I am writing this submission as a part-owner and resident of a nearby residential apartment building that will be directly affected by the Grocon proposal for a 25-storey building and the modification proposal to SSD7338 (MOD 4) – increase in Construction Hours from the approved 0700-1700 Monday to Saturday to 0600-0000 Monday to Saturday.

Tuesday May 22, 2012

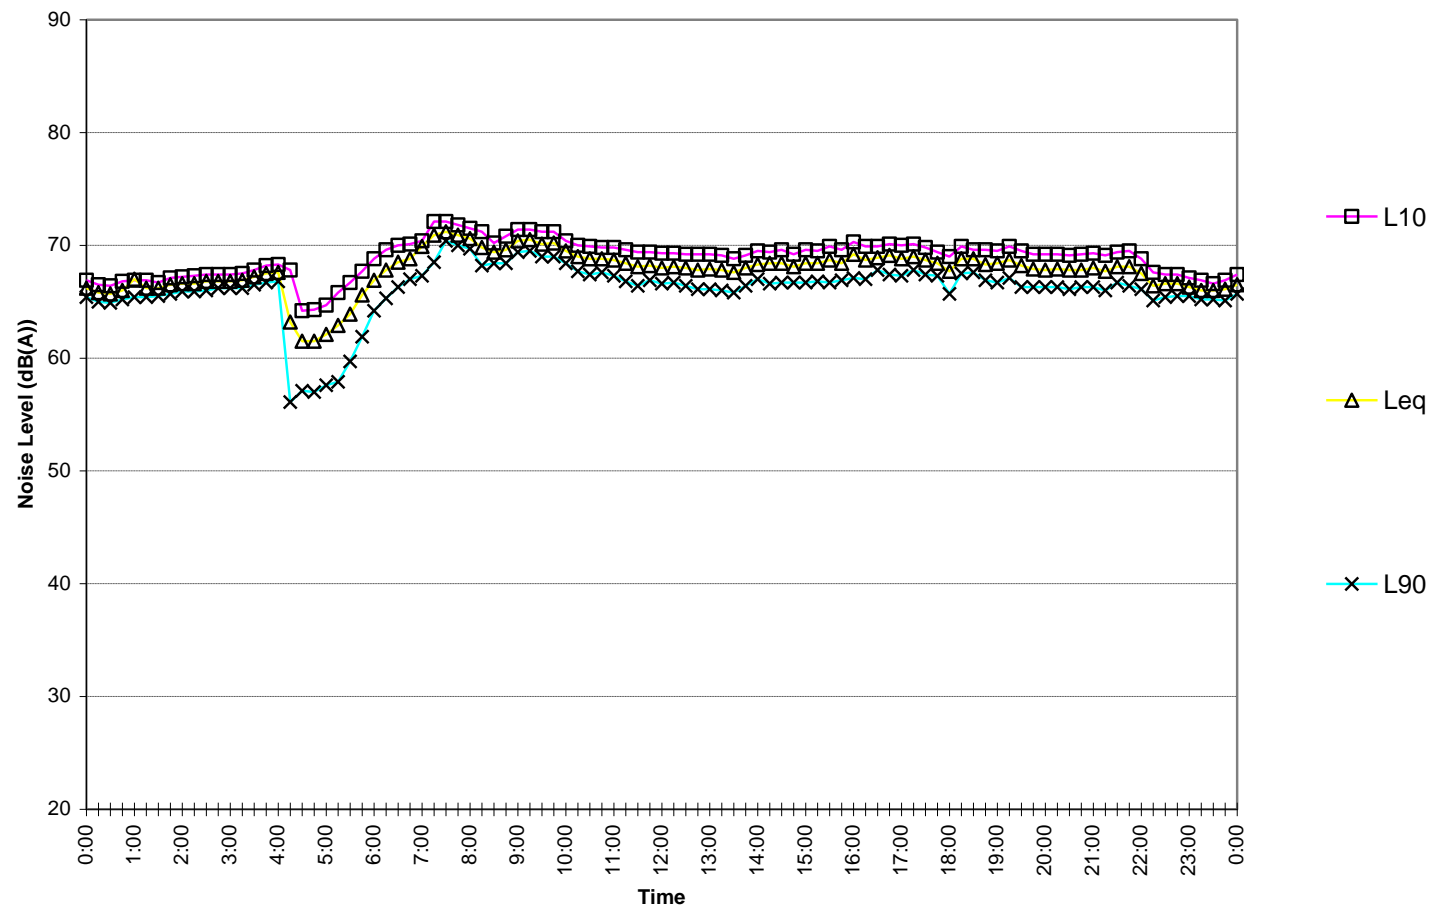
3. There is no Sleep Disturbance Assessment using LA1,1min or LAmax.
4. The Background Noise Monitoring of which the noise assessment is based does not take into account that the background levels are much quieter during weeknights (Sunday to Thursday nights) than on Friday and Saturday nights and it is 5 years old so may not be relevant anymore.
